Response to National Grid's Summary of the Open Floor Hearings  
Project: Norwich to Tilbury Electricity Transmission Project (EN020027)  
Interested Party: Caroline Homewood – [REDACTED], Aldham and Fordham in Colne Valley  
Interested Party Reference number: [REDACTED]

I spoke at the Open Floor Hearing on 10 February 2026 and subsequently submitted written comments summarising the issues raised in relation to the section of the proposed overhead line between pylons TB047–TB052 affecting Ford Street, Aldham and Fordham.

Having reviewed Document 8.5.4 – National Grid's Response to the Open Floor Hearings, I am concerned that National Grid's summary does not adequately address the substance of the evidence presented about this section of the route.

Figure 4.3 Fordham and Fordstreet

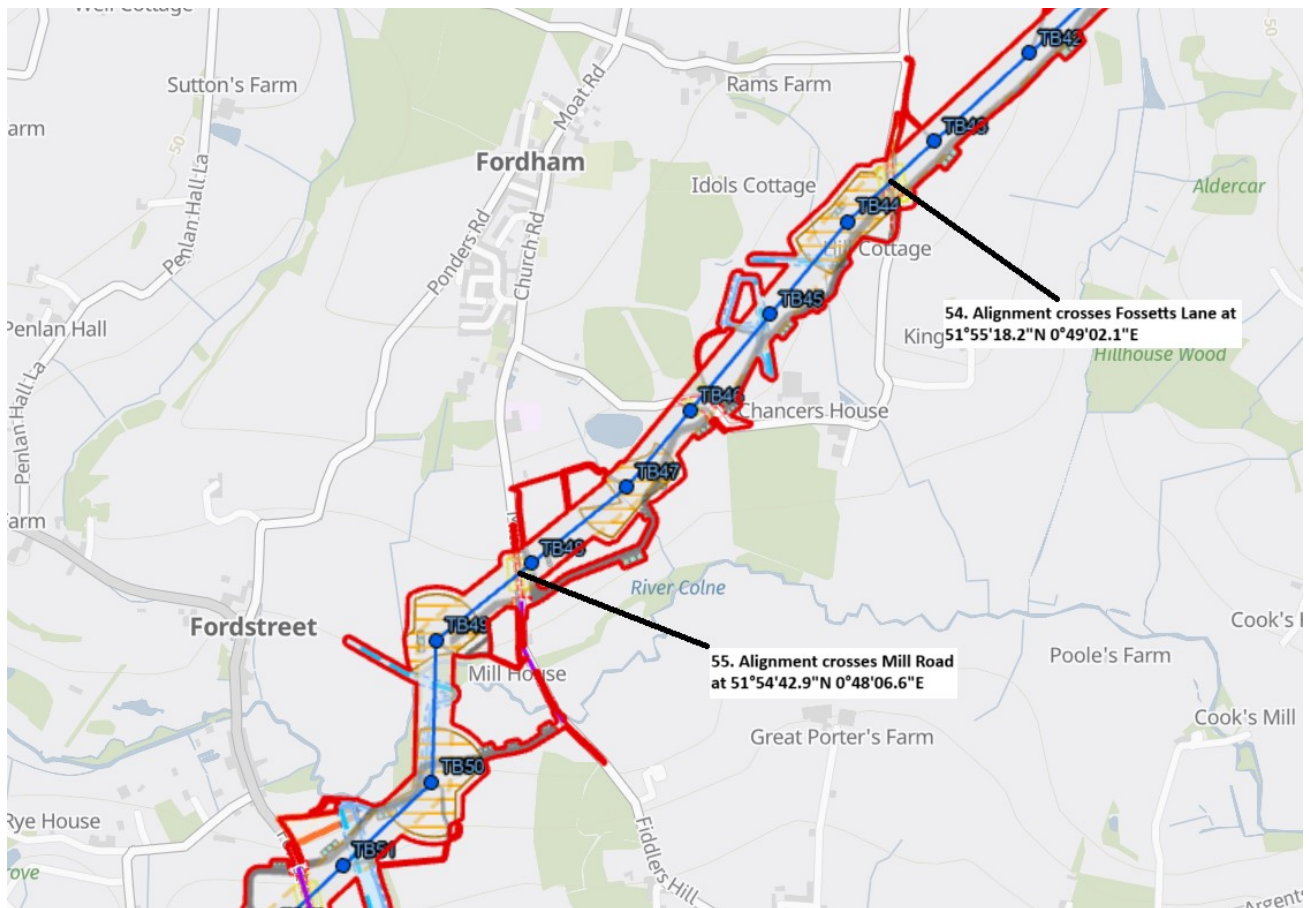
National Grid states that moving the alignment westwards would bring the route closer to the Ford Street Conservation Area and therefore rejected that alternative. However, the preferred alignment places multiple 50-metre pylons on elevated ridgelines immediately surrounding Ford Street, creating prominent skyline structures that will tower above and visually encircle the historic village. It is therefore unclear how proximity to the Ford Street Conservation Area was considered a constraint in rejecting alternative routes, while the chosen alignment places highly visible ridge-top pylons directly around the settlement. In addition, it has come to light National Grid want to erect a construction compound in the Ford Street Conservation Area.

- a) the placement of 50-metre pylons on elevated ridgelines, breaking the skyline above villages
- b) harm to the setting of designated heritage assets including Fordham Church (Grade I), Aldham Church (Grade II\*) and the Ford Street Conservation Area
- c) potential impacts on Roman archaeological remains near pylon TB047
- d) impacts on the Essex Way long-distance path and recreational landscape
- e) fragmentation of habitats within the Colne Valley landscape
- f) the cumulative visual impact of pylons encircling the village of Ford Street.

The alignment between TB047 and TB052 appears to conflict directly with these principles by placing pylons on elevated ridgelines above settlements within the Colne Valley.

Following the hearing, I received a plan indicating that land behind The Maltings in Ford Street is proposed for compulsory purchase for a construction compound.

This location is known locally to flood each year.

The proposed siting of a construction compound within the Ford Street Conservation Area and on land subject to seasonal flooding raises further planning concerns which are not addressed in National Grid's response and contradicts the statement it makes in its response.
